TECHNICAL MEMORANDUM

Date: March 7, 2019

Subject: Review of Sound Management Plan

Fig.4.5 Proposed Flight Routes for the new MMC Helipad

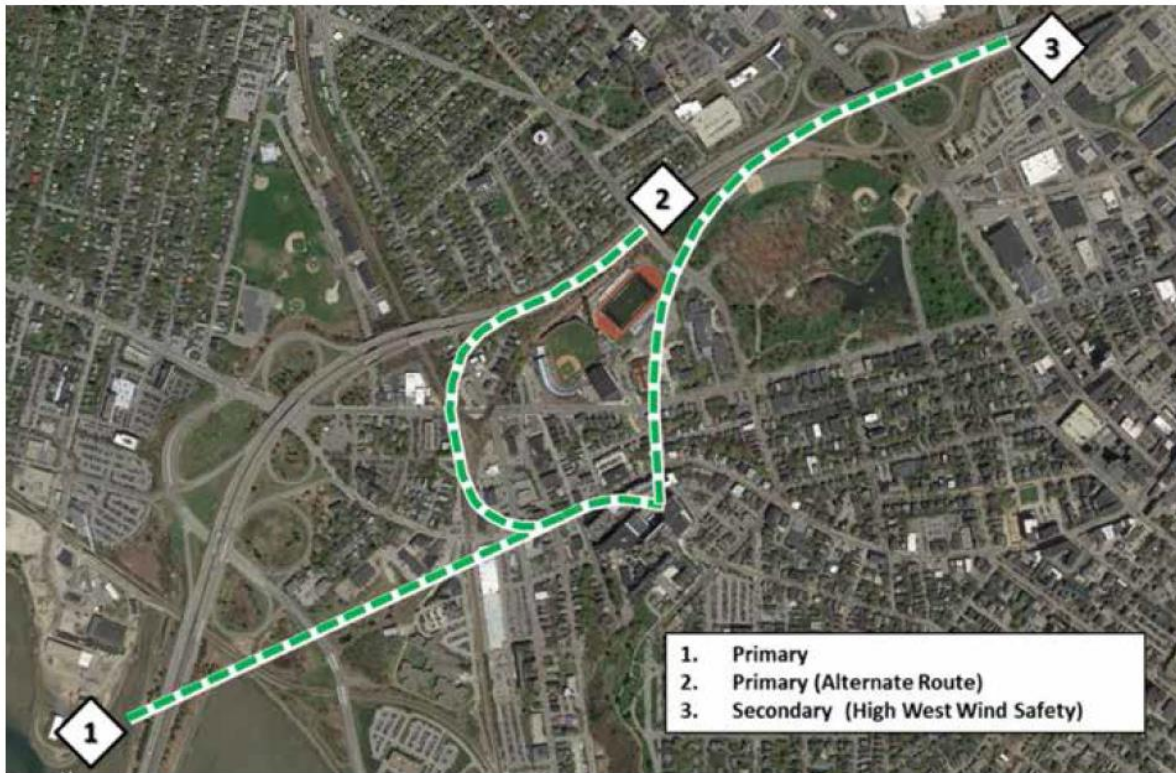
The SMP states they will measure four (4) sorties, each consisting of an approach, a 30-second hover and a departure, but is vague about the path/location stating the existing *and* proposed helipads. It is recommended the SMP specify the sorties approach the East Tower, perform a 30-second hover at the approximate elevation of the proposed helipad (simulating a landing to the pad and a takeoff from the pad), and depart the East Tower, on the proposed flight tracks shown in Figure 2 of the 2017 noise study (Russell Acoustics 2017)², reproduced here as Figure 2. Also, the SMP should specify whether the sorties will utilize approach paths 1 or 2 (or a mixture of both) from Figure 2. A mixture, e.g., 2 on each, is preferred. A total of four (4) sorties is probably sufficient, if the flight paths (including altitude and pilot technique) can be documented/verified as being similar to each other, e.g., both flight paths on Track #1, and the approach/departure portions documented/verified as being typical of air ambulance operations.

If the existing flight paths would be noticeably different (beyond the final approach/initial departure), residential areas not addressed by previously measured locations (or justifiably dismissed) and recommended for inclusion in the SMP are representation of areas:

- In between Tracks #1 and #2 and Interstate 295, e.g., houses along Frederic, Westfield or Hemlock Streets.
- In between Tracks #2 and #3, e.g., houses along Valley and/or Gilman Streets, north of Congress Street.

Appendix 6: 2017 Sound Study Measurement Locations

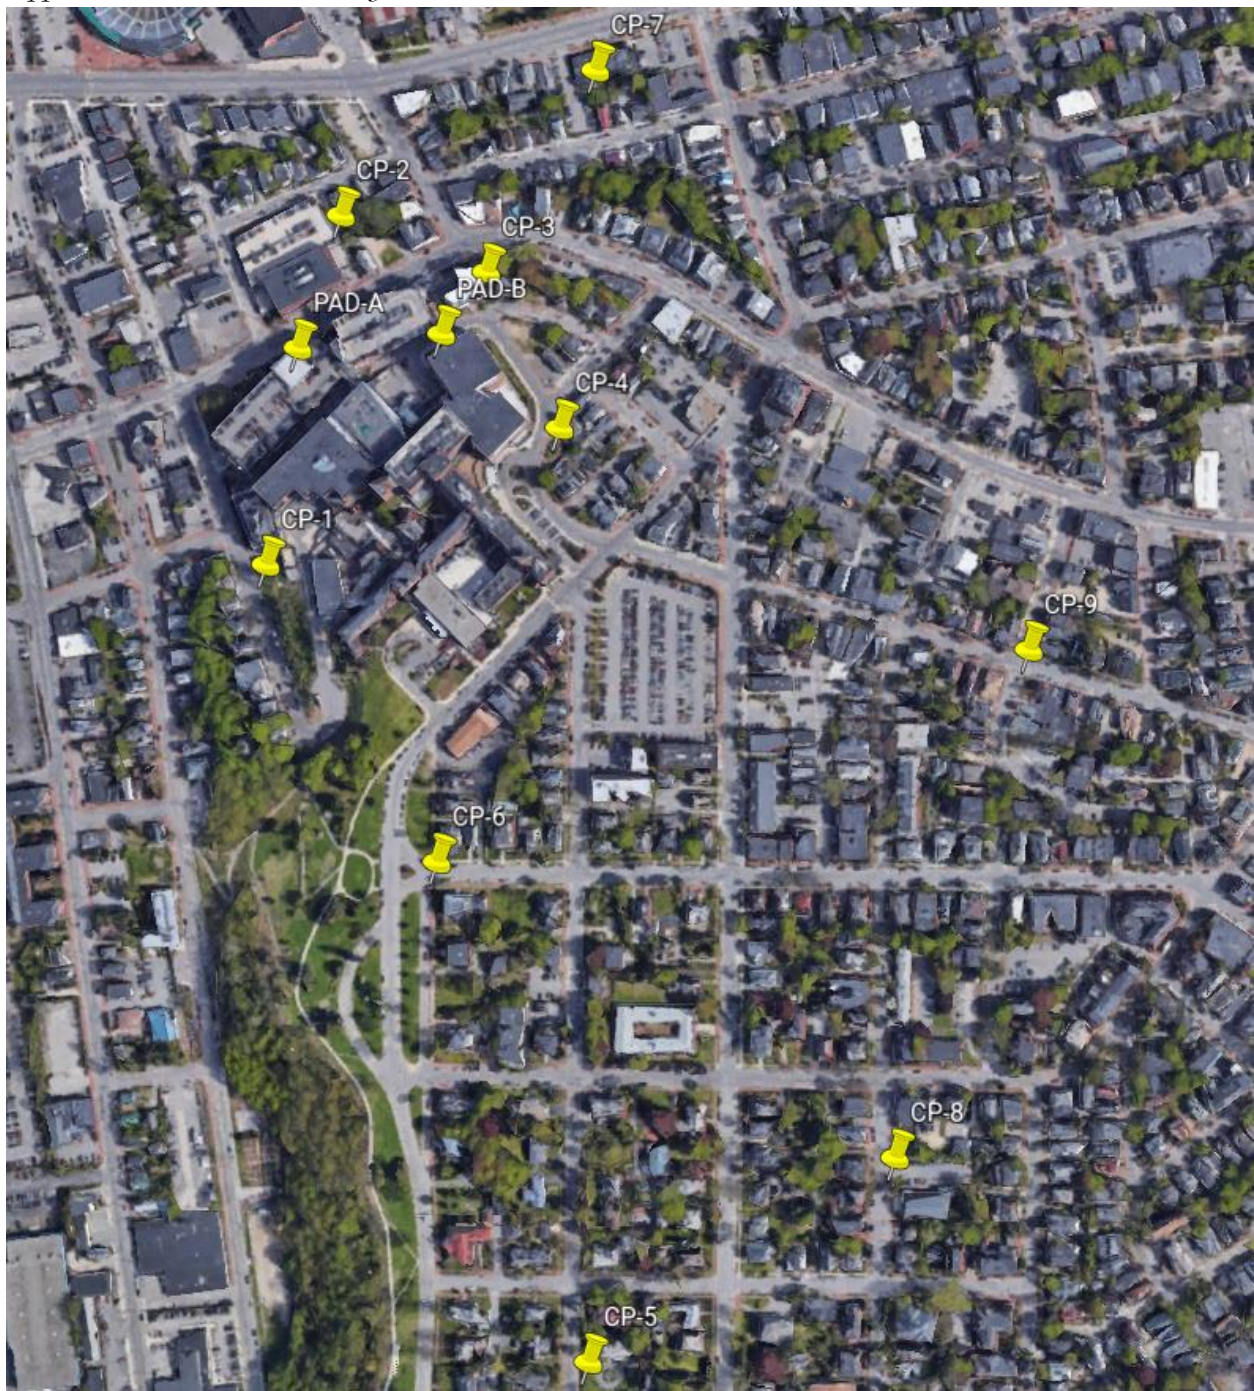
In its section “Location of Sound Devices”, the SMP states it will utilize as many of the previously measured locations as possible to facilitate comparison to the previous studies. Although utilizing *as many of the previously measured locations as possible* is advantageous, the SMP should present or list the locations it plans on measuring, or at least reference them, e.g., Figure 1 from the 2017 noise study (Russell Acoustics 2017). The proposed measurement locations should be shown relative to the proposed flight paths – see Figure 3 below for a rough example. If the proposed flight paths would not differ noticeably from existing flight paths (except for the final approach/initial departure path to the existing and relocated helipads), locations CP-5, 6, 8 and 9 from the 2017 noise study do not seem relevant and can be considered for elimination.

Residential locations east of the MMC, i.e., east of Wescott and Charles Streets but north of Bramhall and Ellsworth Streets, are likely enjoying shielding by the (existing) East Tower to arrivals at (and possibly departures from) the existing heliport. Locations CP-3 and CP-4 bracket the area to the north and south, respectively, but there is not a location in between the two. With the vertical expansion of the East Tower and the relocation of the existing heliport to the East Tower, i.e., closer to this set of receptors, those receptors will likely be exposed to more noise from proposed helicopter operations, even though flights would likely be 100 feet higher at the new heliport. The rule of thumb for aircraft sound propagation loss is 6 dB per doubling of

distance. The closest residences (adjacent to Wescott Street) are approximately 680 feet from the existing helipad but would only be approximately 340 feet from the proposed heliport³. This is approximately a halving of distance, which means a potential 6 dB increase in helicopter noise levels, not including the increase in noise associated with the elimination of the East Tower's shielding enjoyed by the existing heliport when the helicopters are near/on the pad(s), or the planned increase in numbers of flights. Therefore, it is recommended a location in this area be added to the SMP.
